# Charlotte Department of Transportation

## Memorandum

**Subject:** Rezoning Petition 08-063: Located on the west side of Beam Road  
between Center Park Drive and Shopton Road

REZONING CONDITIONAL SITE PLAN
 REQUESTED CHANGE FROM I-1 (CD) TO B-D (CD)

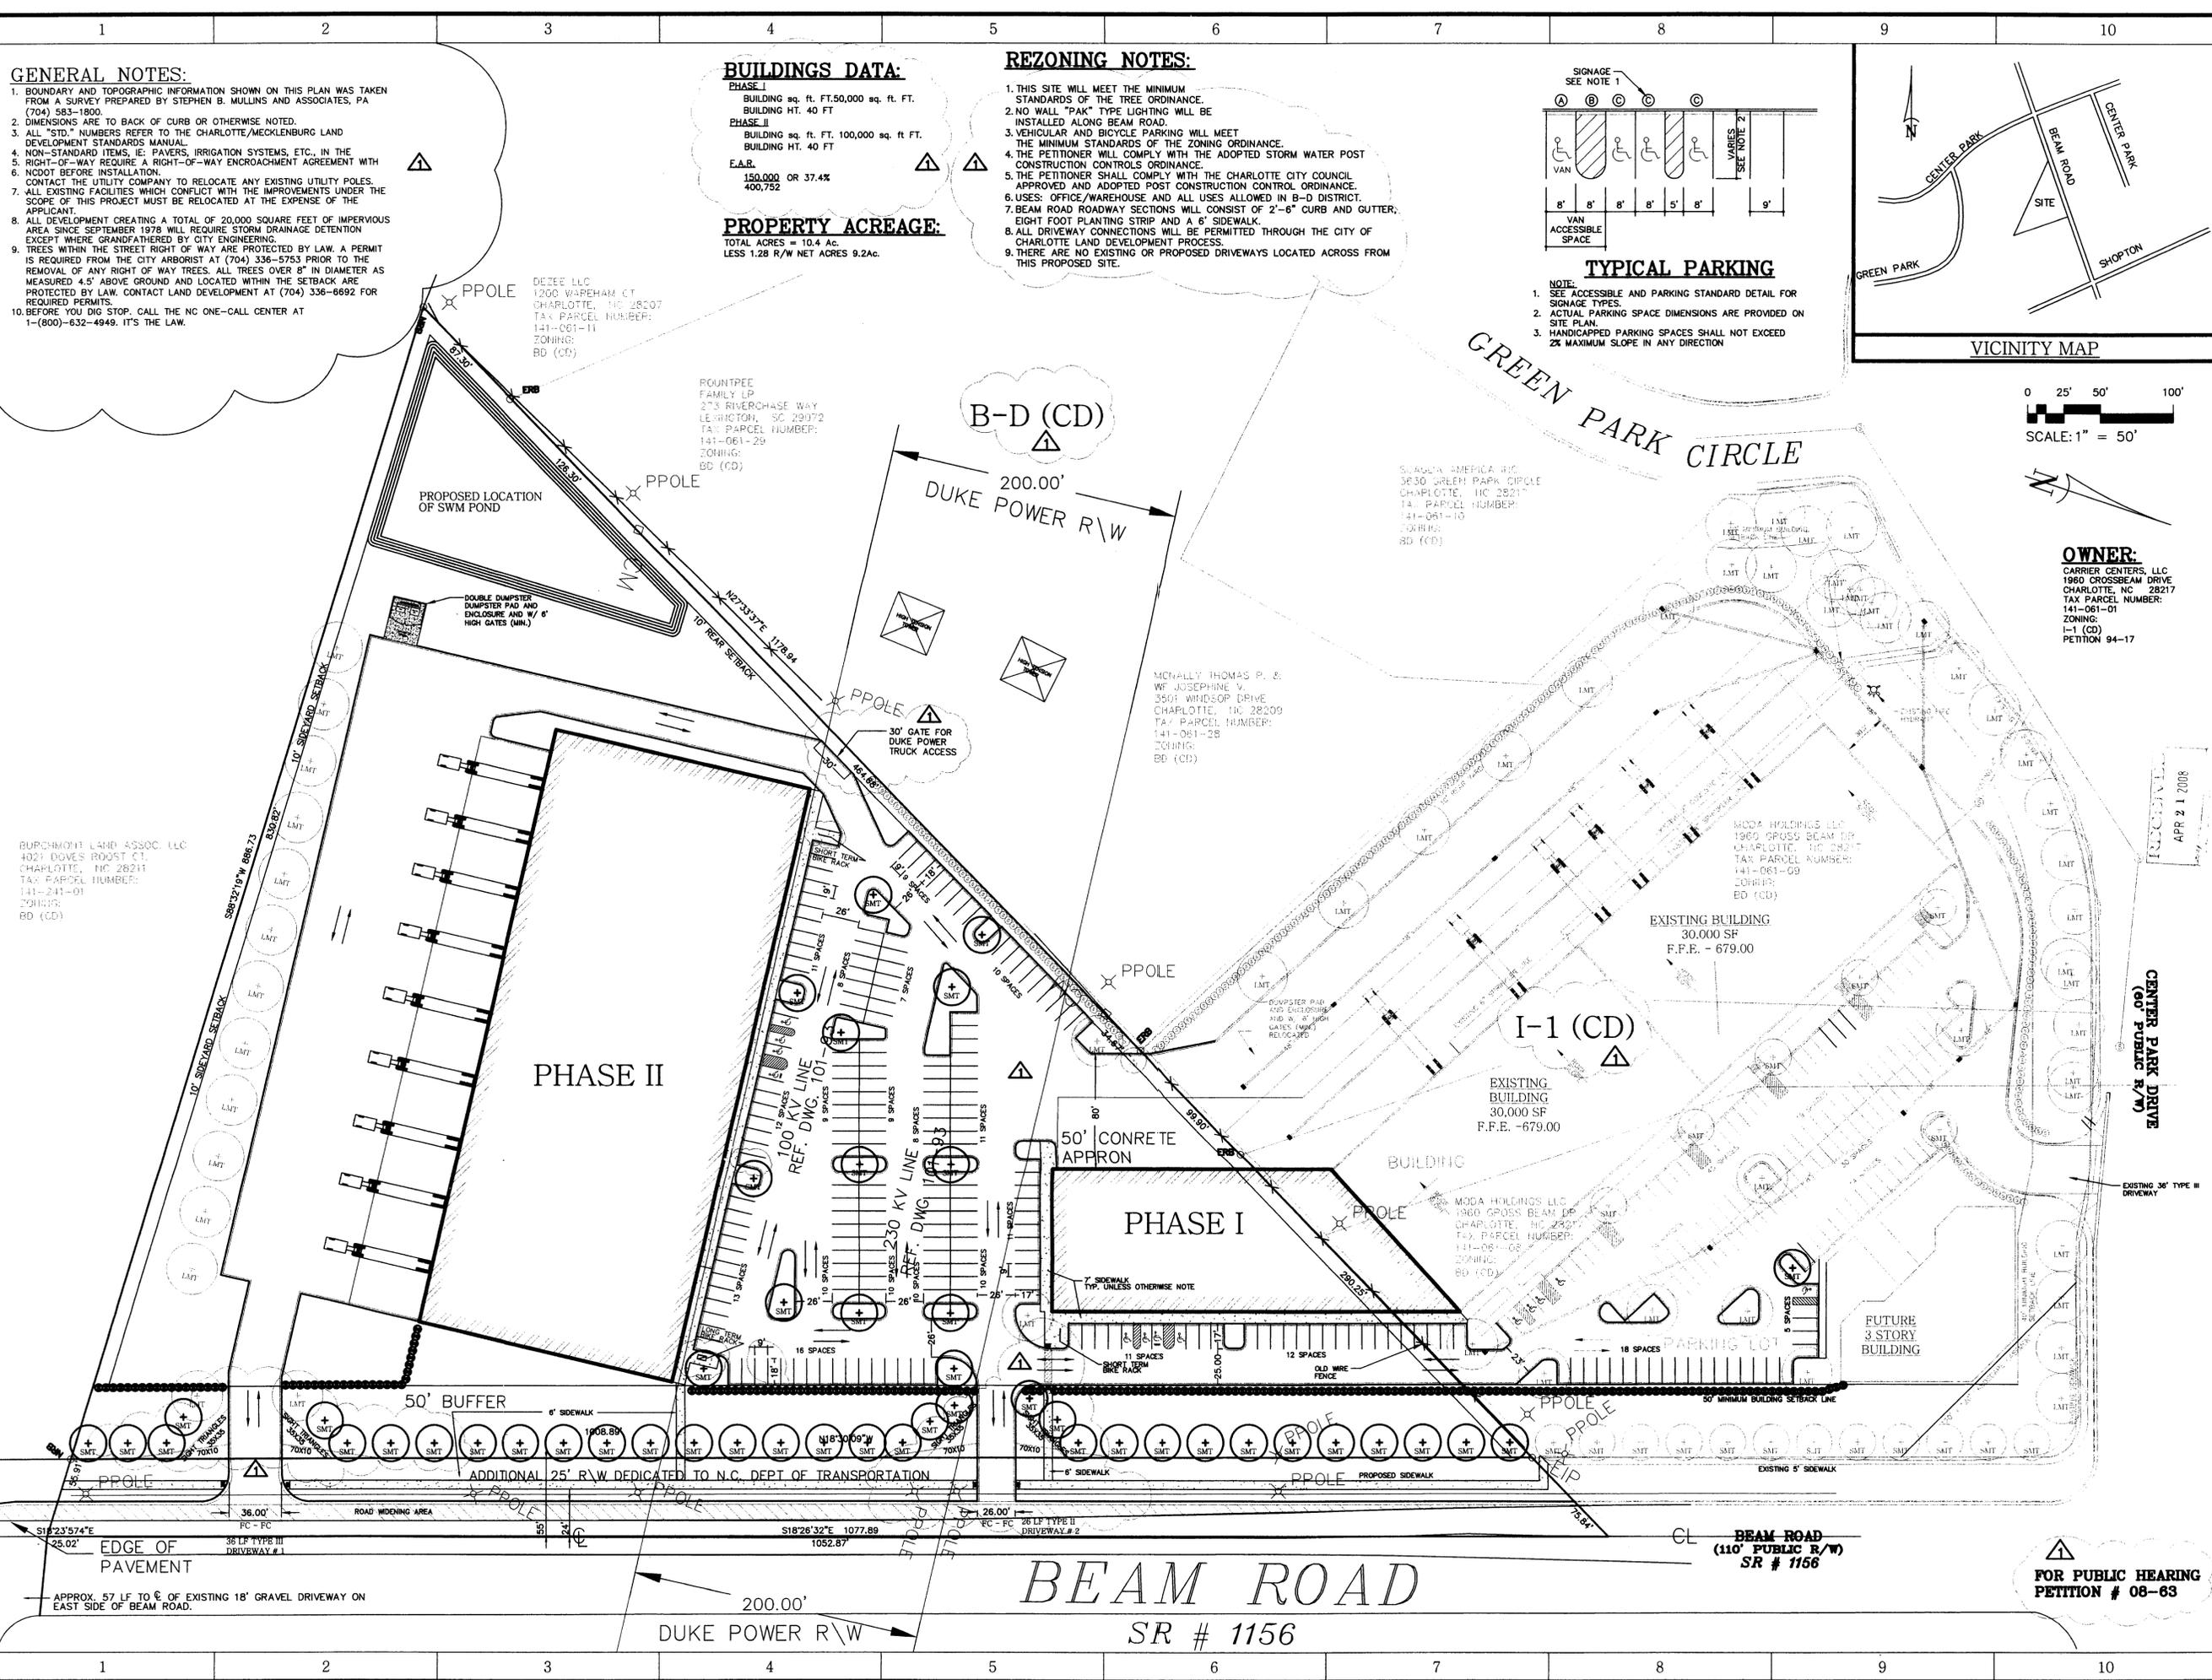
1. The entrance to phase 1 of the development needs to directly align with the parking aisle to eliminate the minor offset.
2. Curb and gutter needs to be installed along Beam Road measured 24 feet from the centerline to the face-of-curb.
3. An 8-foot planting strip and 6-foot sidewalk needs to be installed along Beam Road from one property line to the other.

1. It is requested that the site plan provide an internal system of 5' or wider sidewalks that connects building entrances to the newly extended sidewalk along Beam Road.

Beam Road is a minor thoroughfare requiring a minimum of 70 feet of right-of-way. The existing right-of-way along the property's frontage is 60 feet (30 feet from the centerline in width). The developer/petitioner has indicated that he will dedicate 25 feet of additional right-of-way to match the existing 110 feet of right-of-way north of the site. We request that the developer/petitioner convey this additional right-of-way in fee simple title, measuring a total of 55 feet from the centerline of the roadway.

Adequate sight triangles must be reserved at the existing/proposed street entrance(s). Two 35' x 35' and two 10' x 70' sight triangles are required for the entrance(s) to meet requirements. All proposed trees, berms, walls, fences, and/or identification signs must not interfere with sight distance at the entrance(s). Such items should be identified on the site plan.

- Dimension width of the existing and proposed driveways.

- New/reconstructed driveways must be a Type III and a drop-curb ramp Type II driveways as shown on the site plan.
- Indicate the locations and widths of all adjacent and opposing driveways.
- Indicate typical parking module dimensions (add stall depth and aisle dimensions).
